Reference: MP 10_0057 MOD 3 /
4 October 2011

Council comments in response to *notification of modification request to amend Condition B1A(f) and B12(a) at 132-138 Killeaton Street, St Ives (MP 10_0057 MOD 3)*

DRAWING TITLE:
CARPARK PLANS

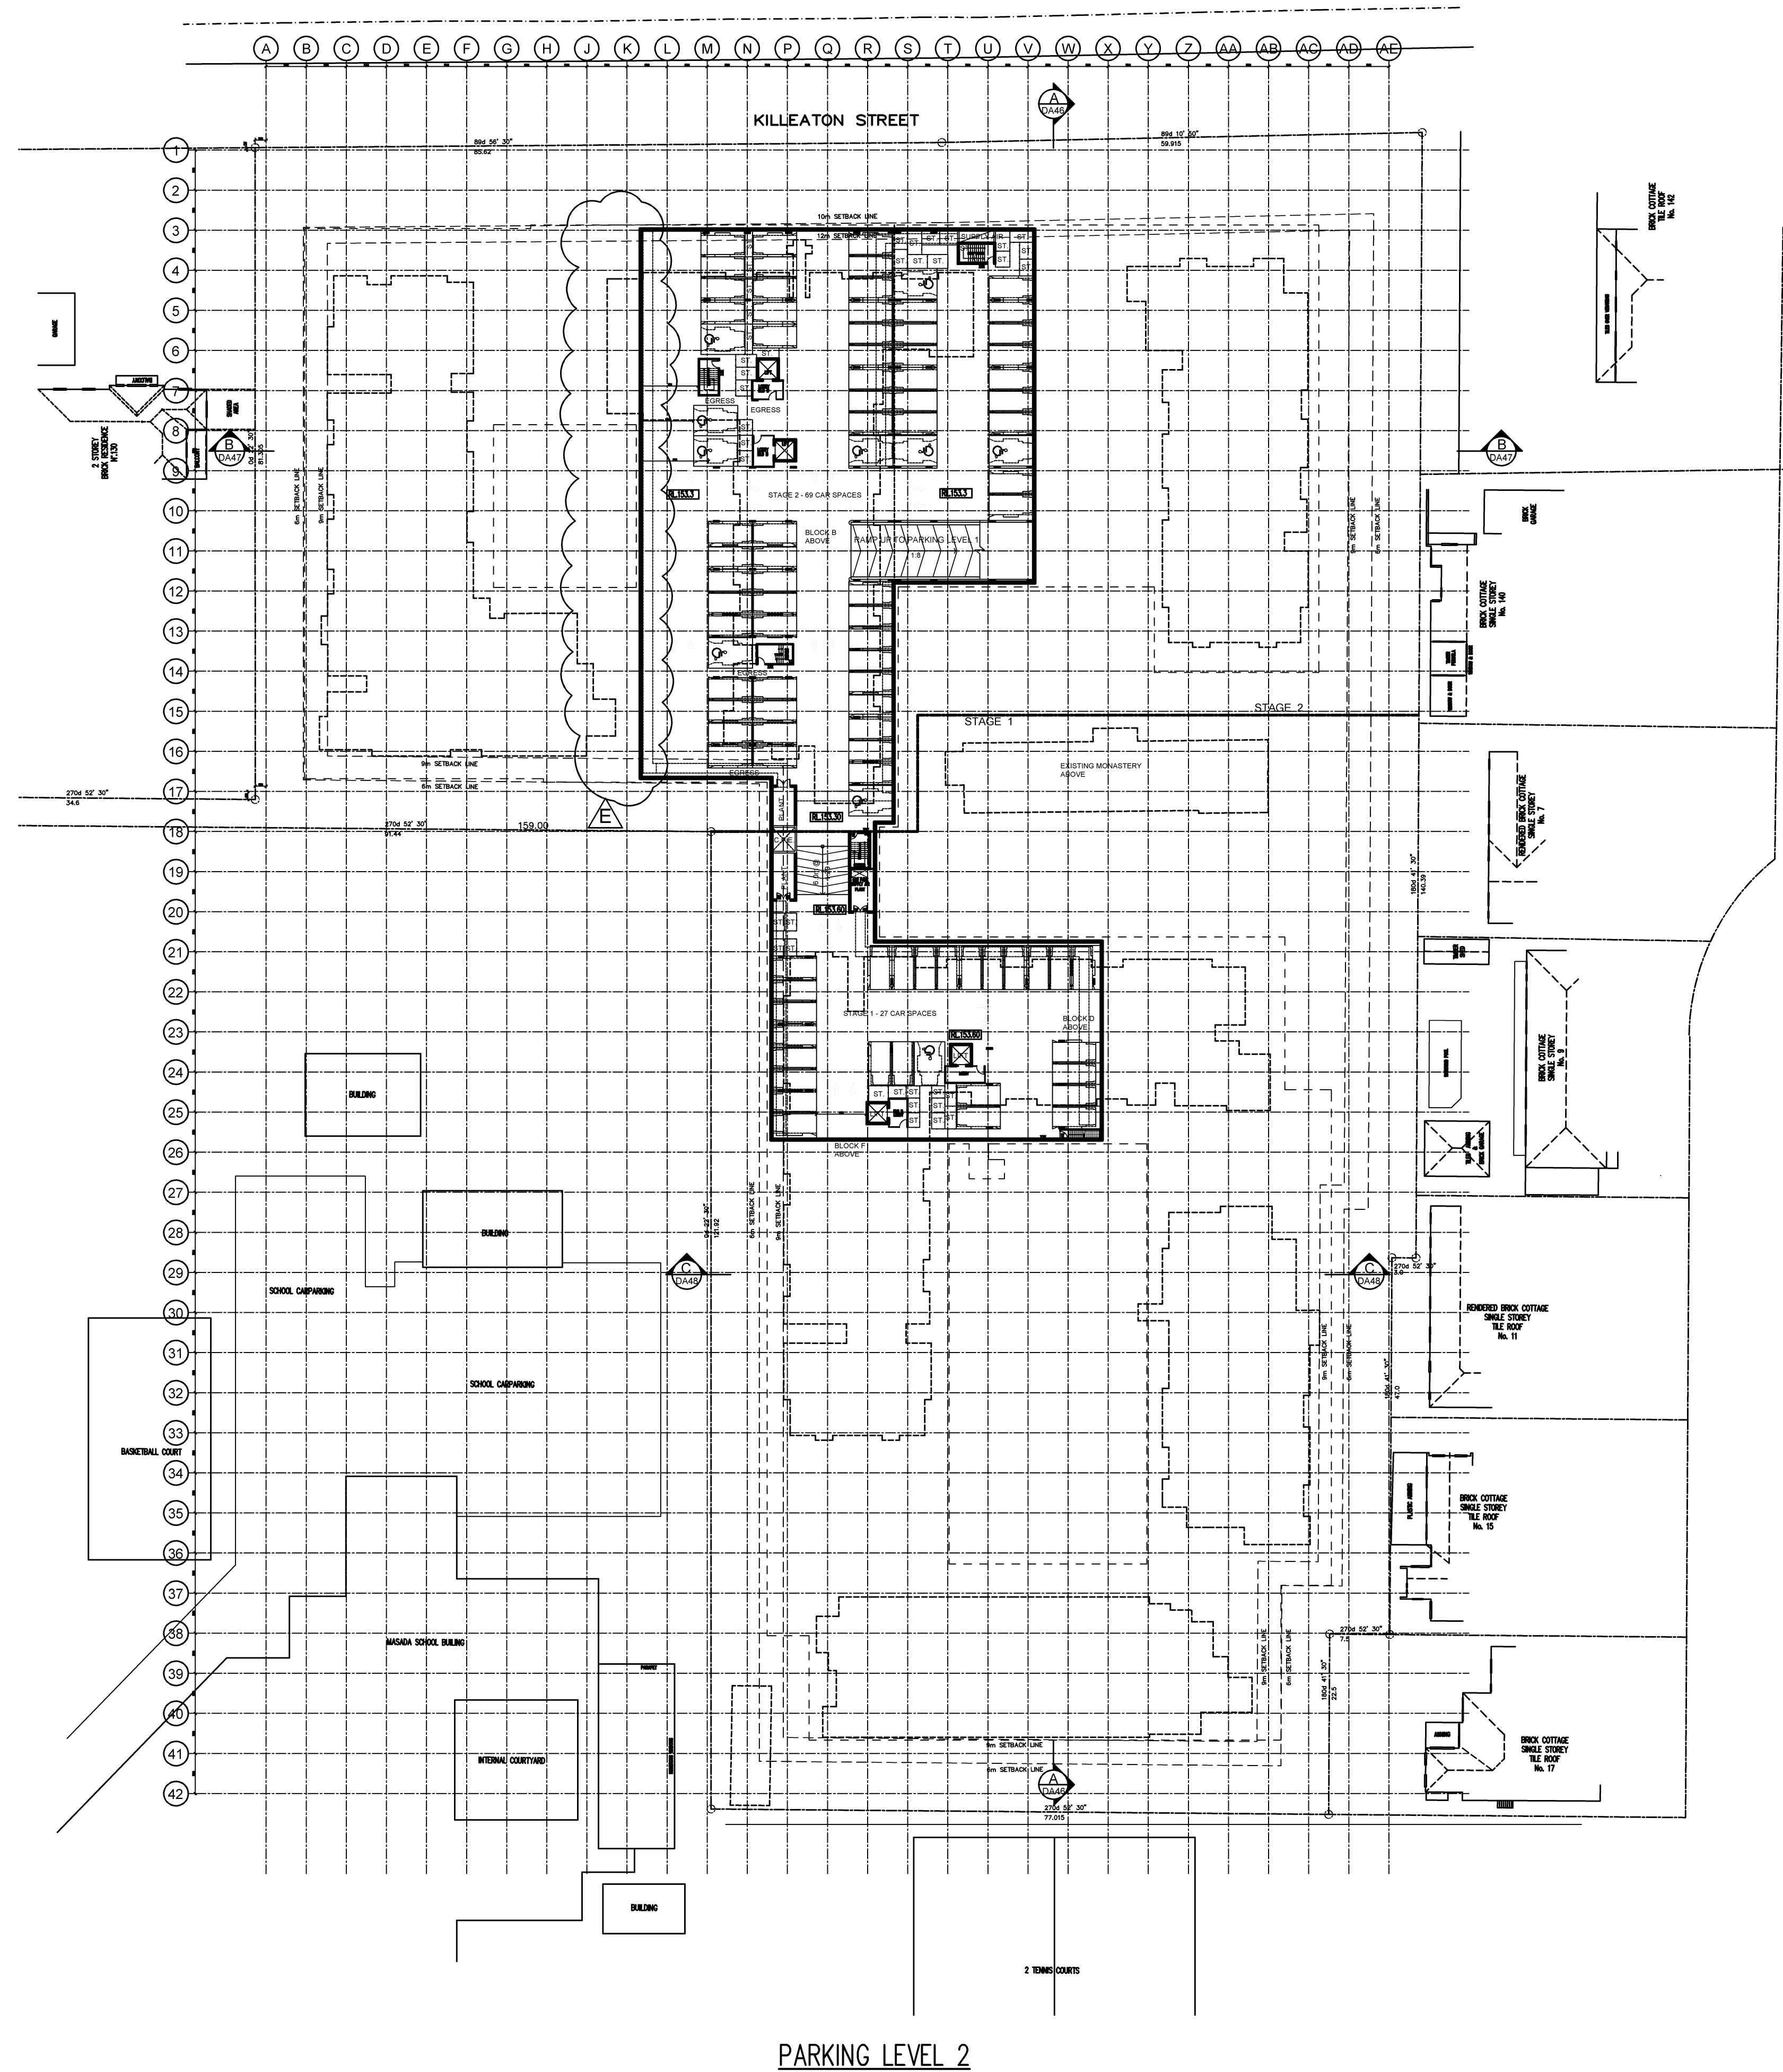
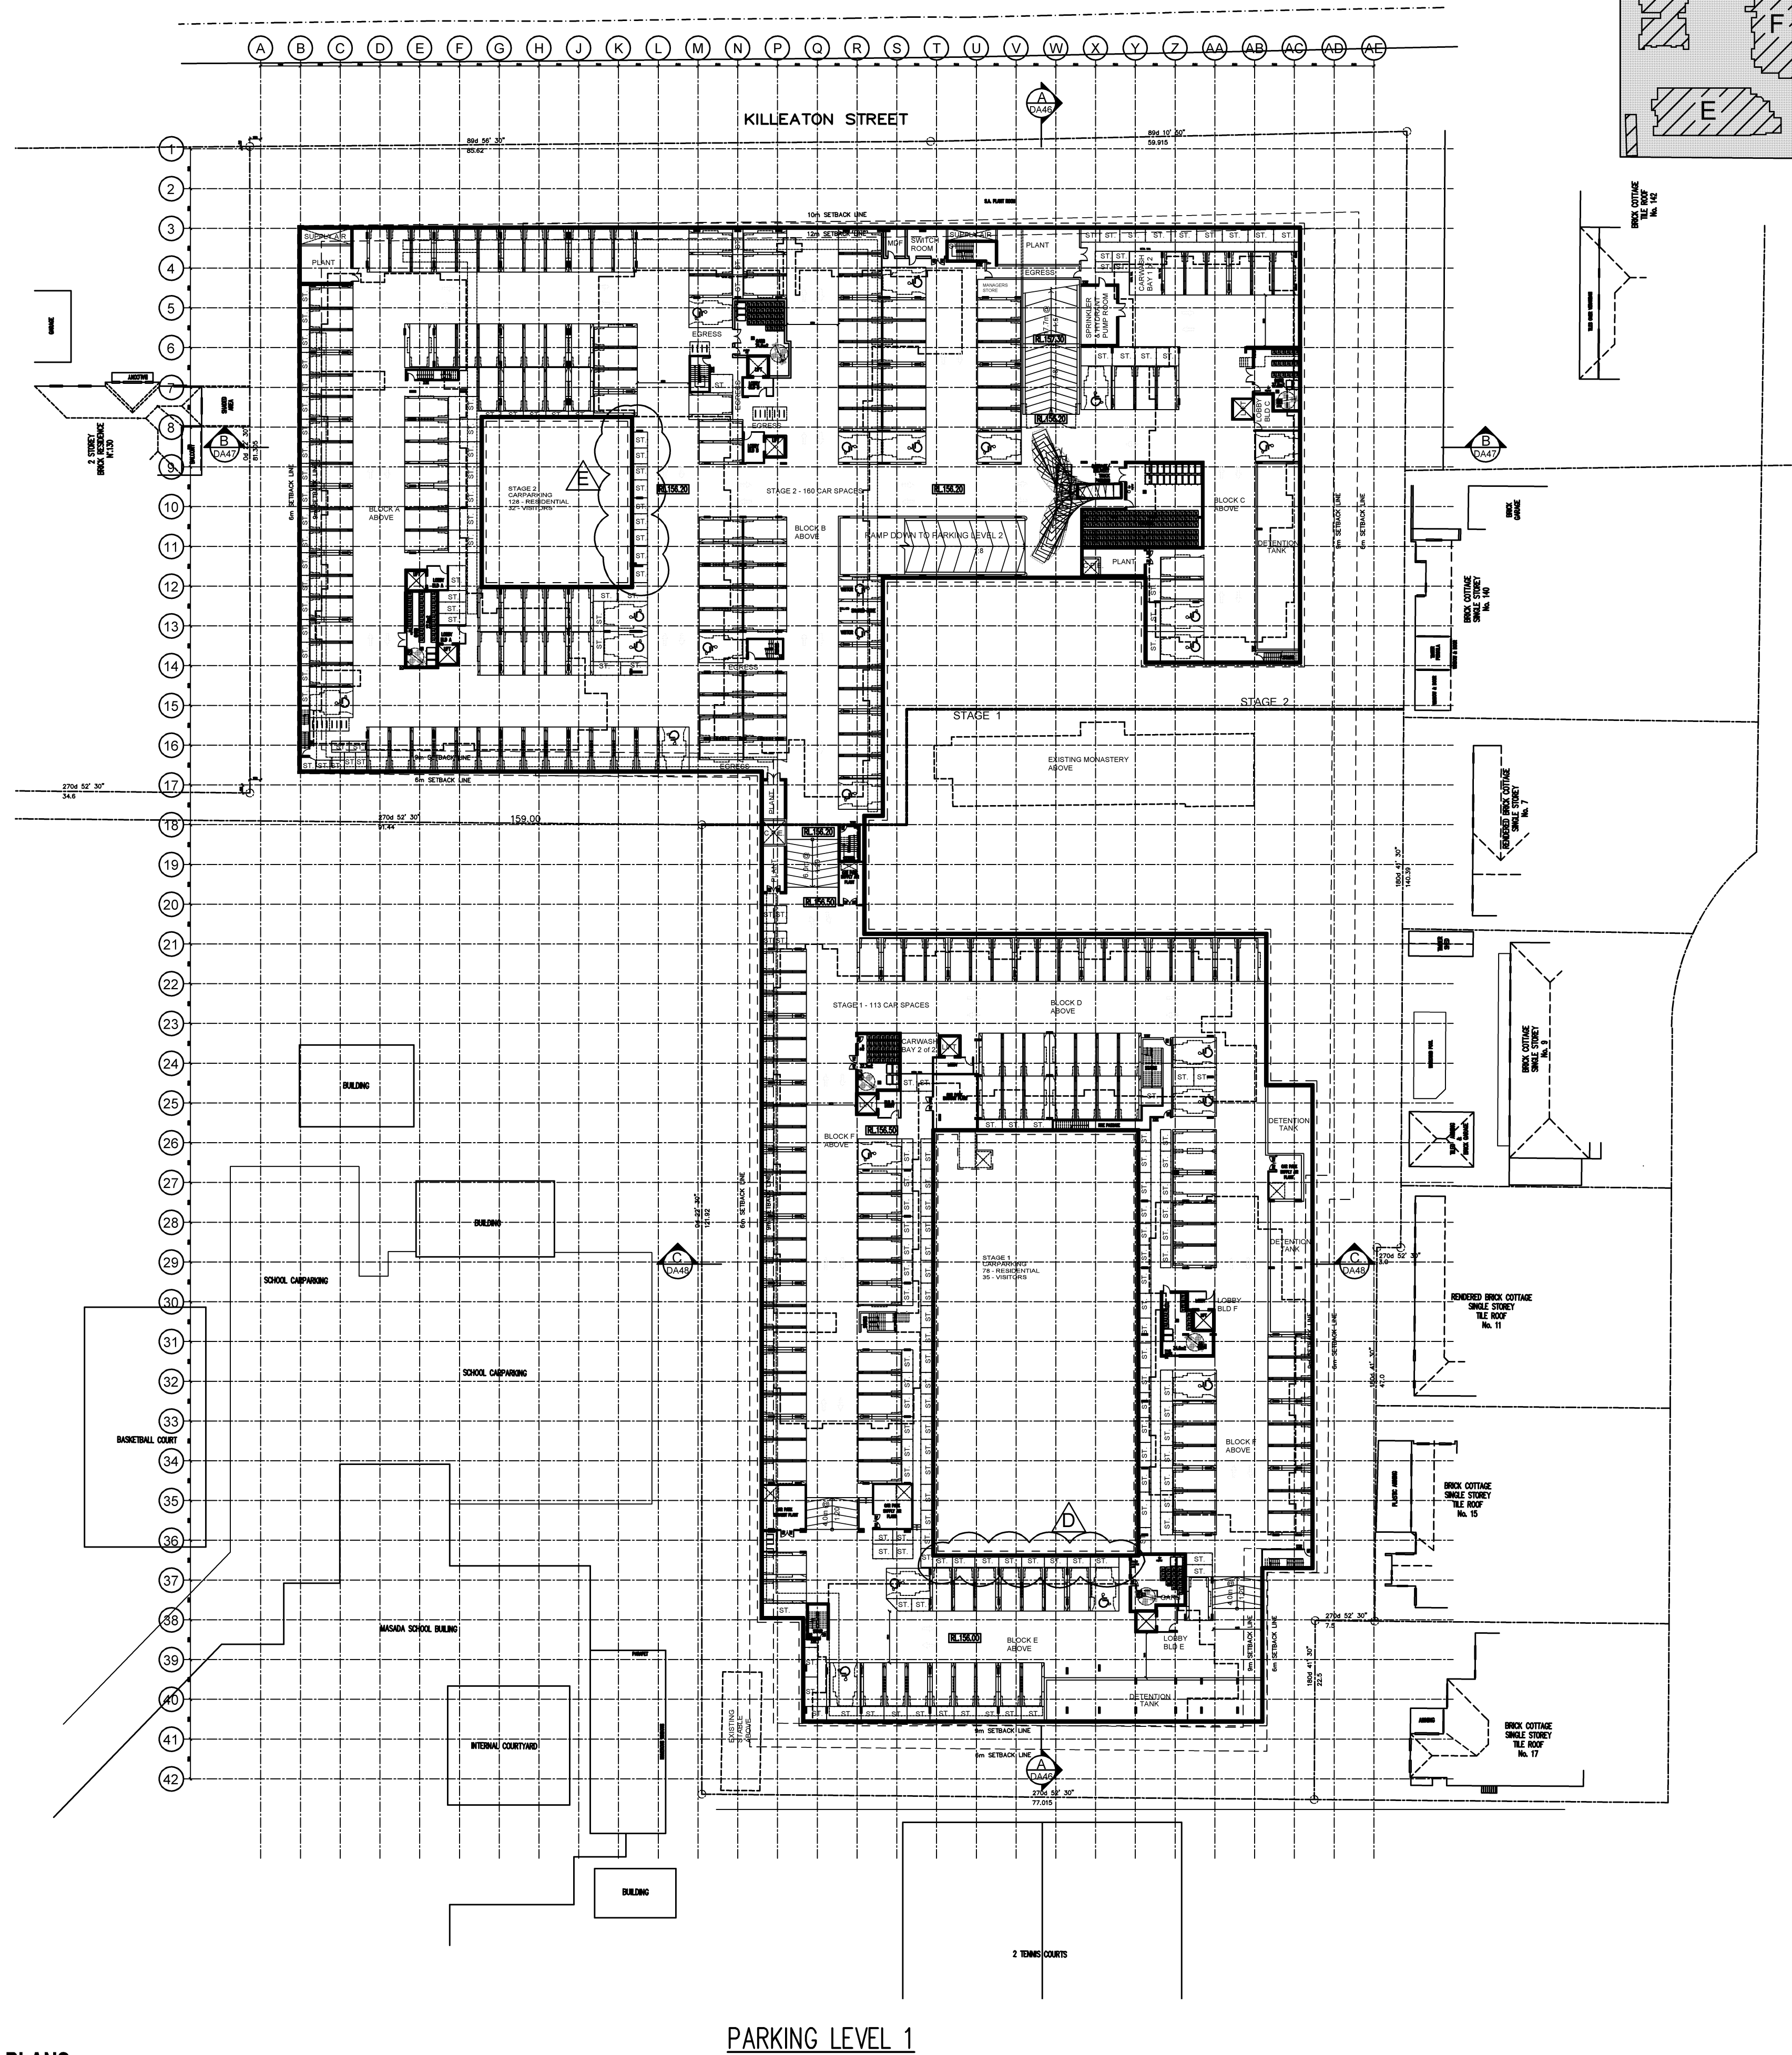
The proposed amendment will reduce the visitor parking provision from 75 spaces to 48 spaces, with existing resident parking spaces to remain the same.

The visitor parking provision of 75 spaces was made in accordance with Council's DCP (Town Centres) 2010, as well as Council's DCP43 (Car Parking), which required visitor parking at the rate of 1 space per 4 dwellings. The proposed amended visitor parking provision of 48 spaces equates to a visitor parking provision at the rate of 1 space per 6.2 dwellings (approx), which is lower than both Council's DCP (Town Centres) 2010 and Council's DCP43.

While a reduction may be appropriate in a Ku-ring-gai town centre that is supported by a combination of rail station, bus services and local employment/core retail and commercial services; it is considered that visitor parking rates in St Ives should be retained at a ratio of 1 space per 4 dwellings. This is based upon the above, but of equal importance, while St Ives has a number of relatively good frequency bus services, it does not have a rail station nor significant local employment (apart from retail activities in the town centre itself). Further, the site is some 600m in a straight line (or 700m walking distance) from the retail core (intersection Mona Vale Rd and Memorial Ave), and as such the site is unlikely to benefit from multi-purpose trips from visitors to the town centre which may also be visitors to the apartments. Failing to provide adequate visitor parking may result in impacts on-street and to surrounding residents.
